PLANNING AMENDMENT

APPLICANT NAME AND ADDRESS BLM BUILDERS LTD DOUGLAS HORSESHOE ROAD SPADING Lincs PE11 3JA. Telephone:	AGENT NAME AND ADDRESS JULIAN NARRICK 8 BEECH GROVE EDNINGTON Lincs PE11 4XD Telephone: 07849 652067
SITE ADDRESS DETAILS REAR OF WAR MEMORIAL, SEAS END ROAD MOLLTON SEAS END, SPADING PE12 6LD.	
CURRENT APPLICATION NO: This amendment cannot be considered unless the relevant reference is stated.	H13-0507-24
Building Regulation reference relating to same development (if applicable)

FULL DESCRIPTION OF DEVELOPMENT OF CURRENT APPLICATION THAT THIS AMENDMENT RELATES TO	RESIDENTIAL DEVELOPMENT 2 DWELLINGS OUTLINE APPROVAL H13-0651-20
--	---

J185-PL 17C

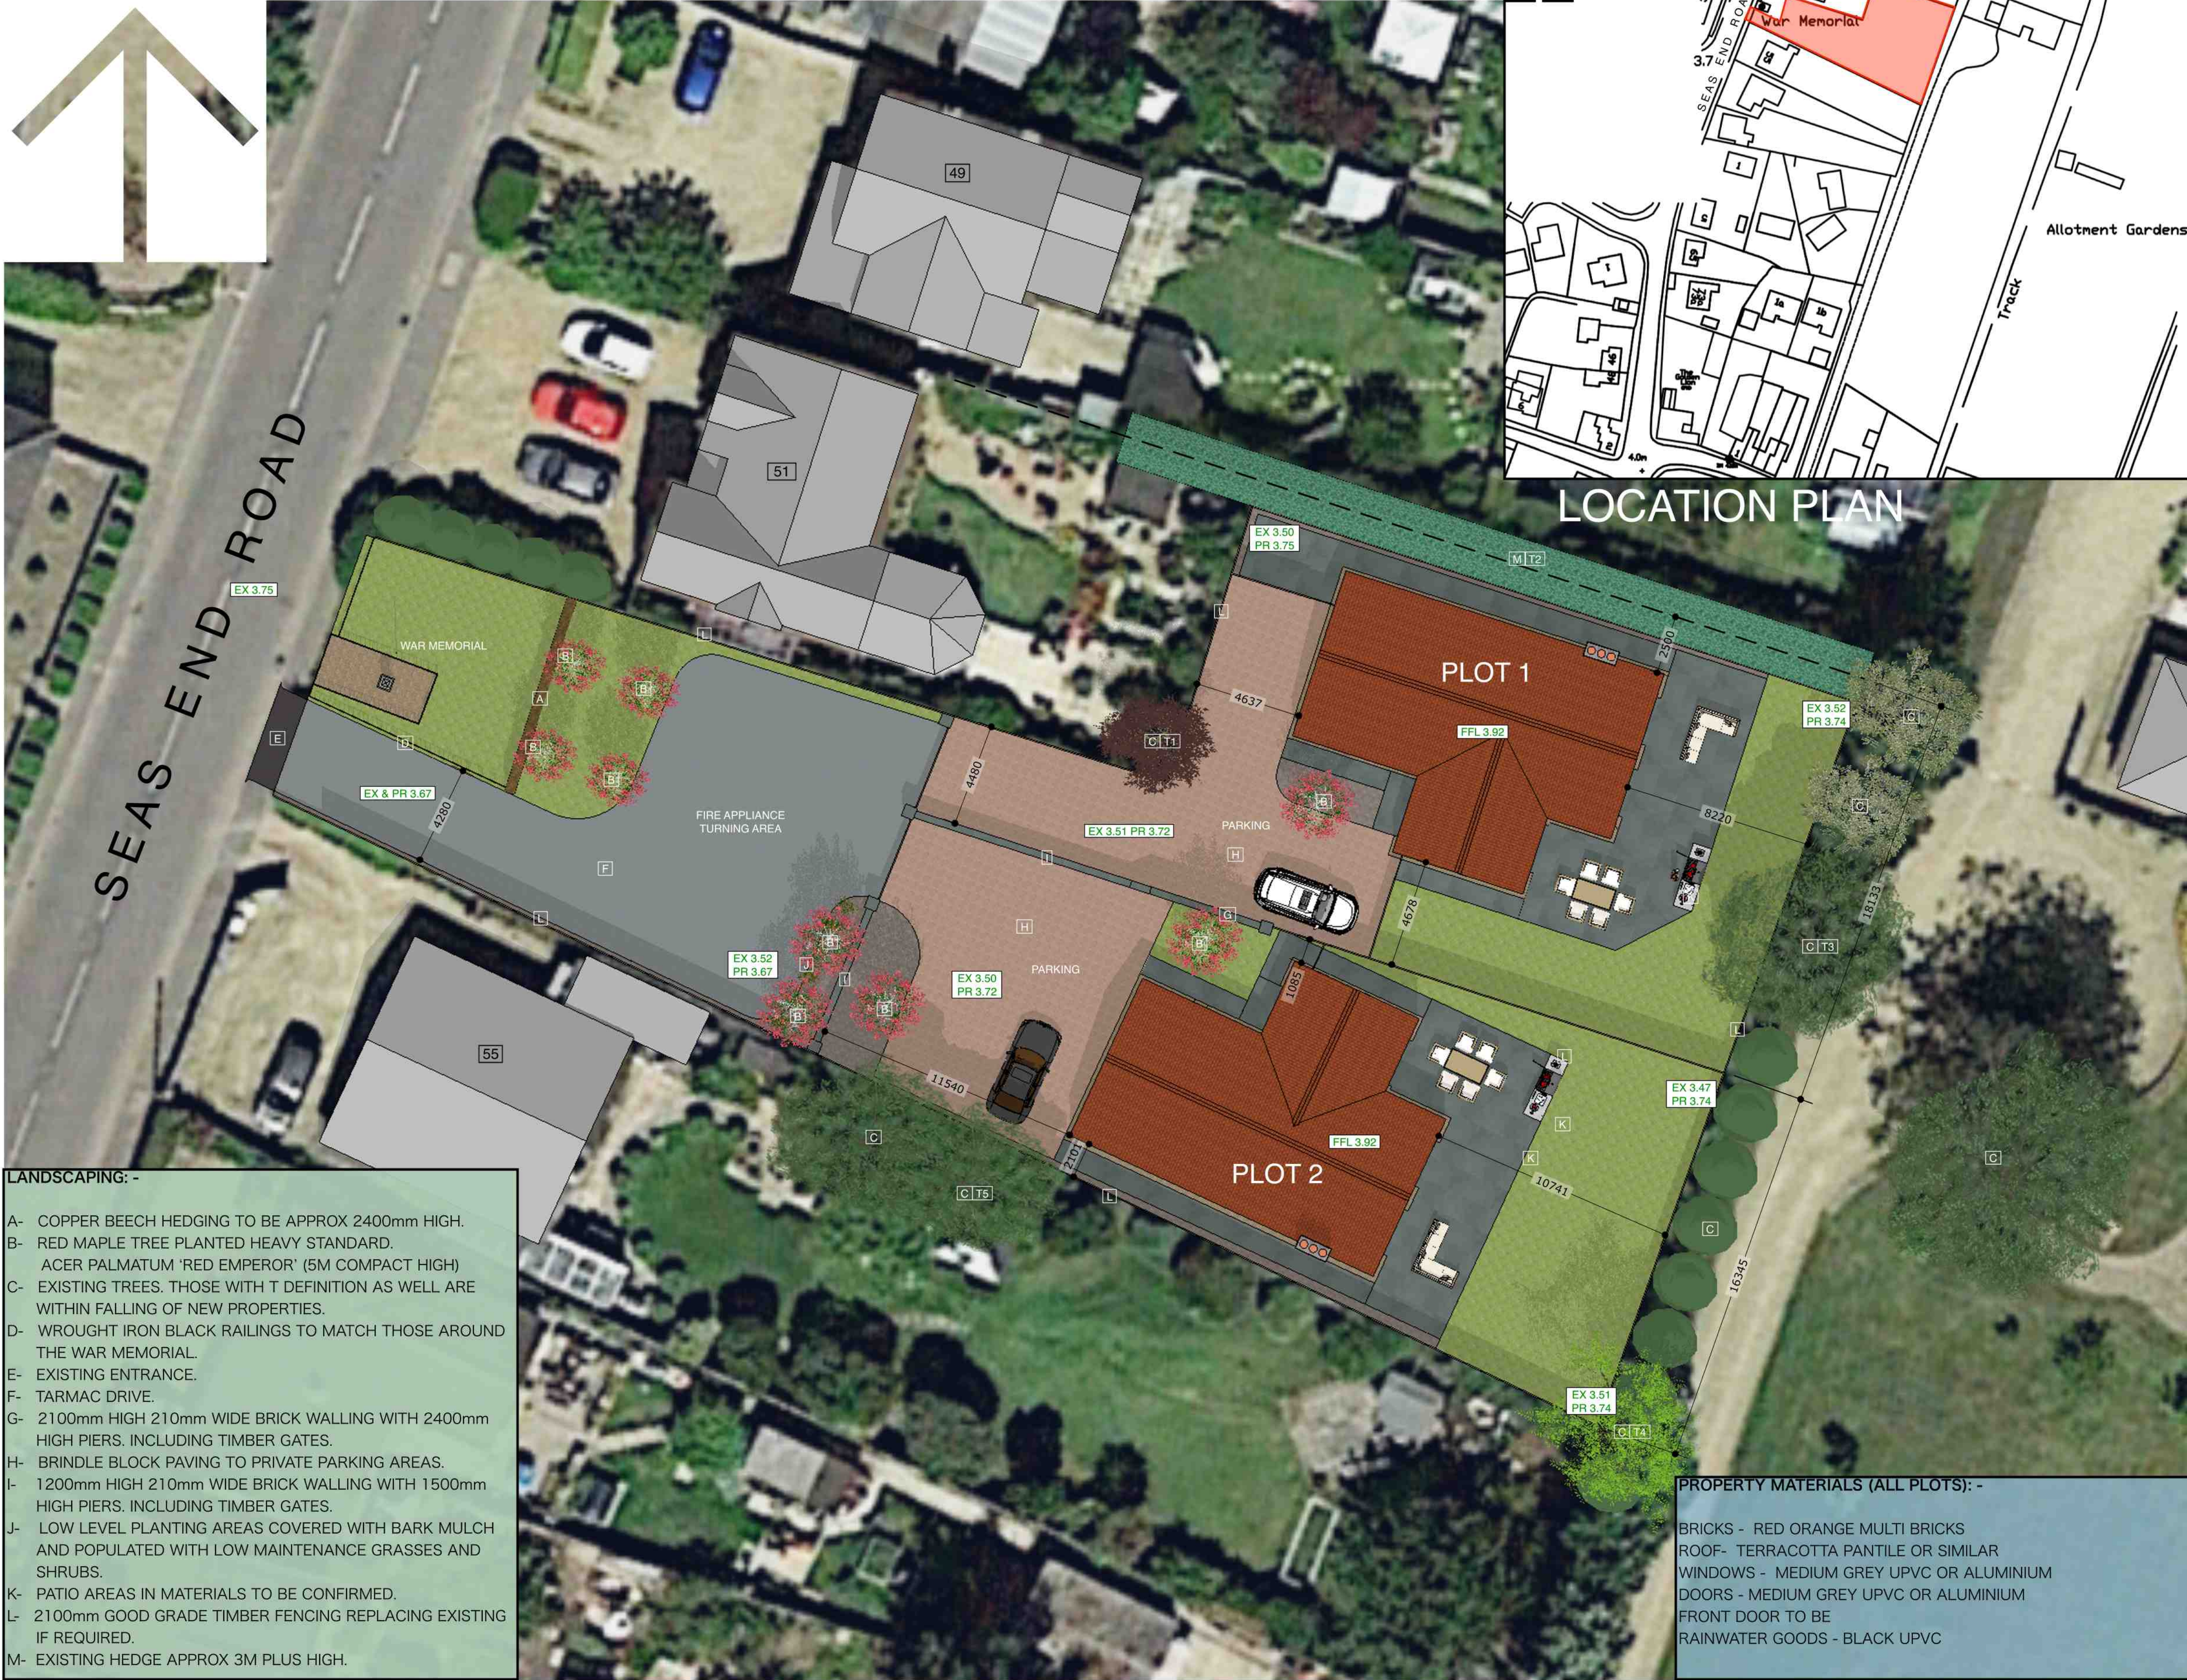
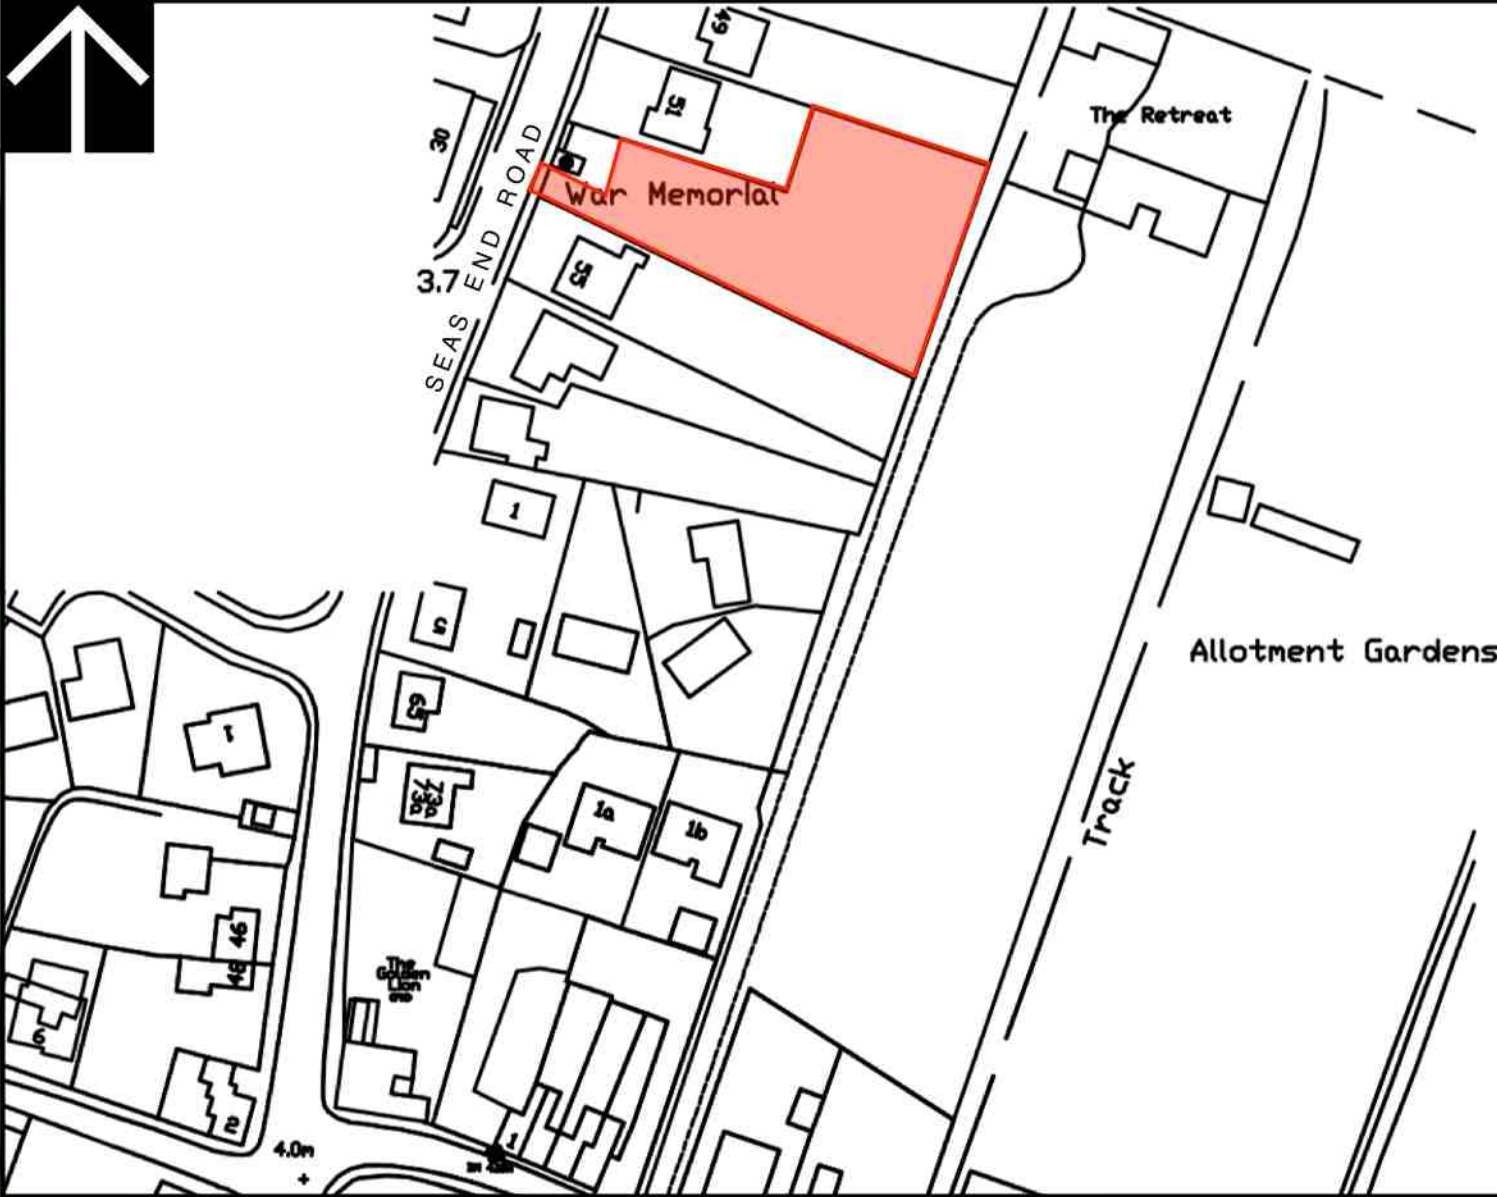
State details of amendments proposed. (Give a full detailed list of the changes, and also mark these clearly on the accompanying plans. Only the changes listed here will be considered)	MAPLE TREES DEFINED TO GROW NO HIGHER THAN 5M. INTO TAKEN OFF WAR MEMORIAL.	
State drawing numbers of the current submission	J185-P17^B, P18, P19^B, P20^B, P21	
Has this amendment been requested by the Council? (If so, state Officer dealing with the application)	YES/ NO	JESS HILL.
Describe any part of the original development which is excluded by virtue of the amendment, and state any alteration to plot numbers		
Has a similar amendment been submitted under Building Regulations? (If so, state Building Control Surveyor dealing with application)	YES/ NO
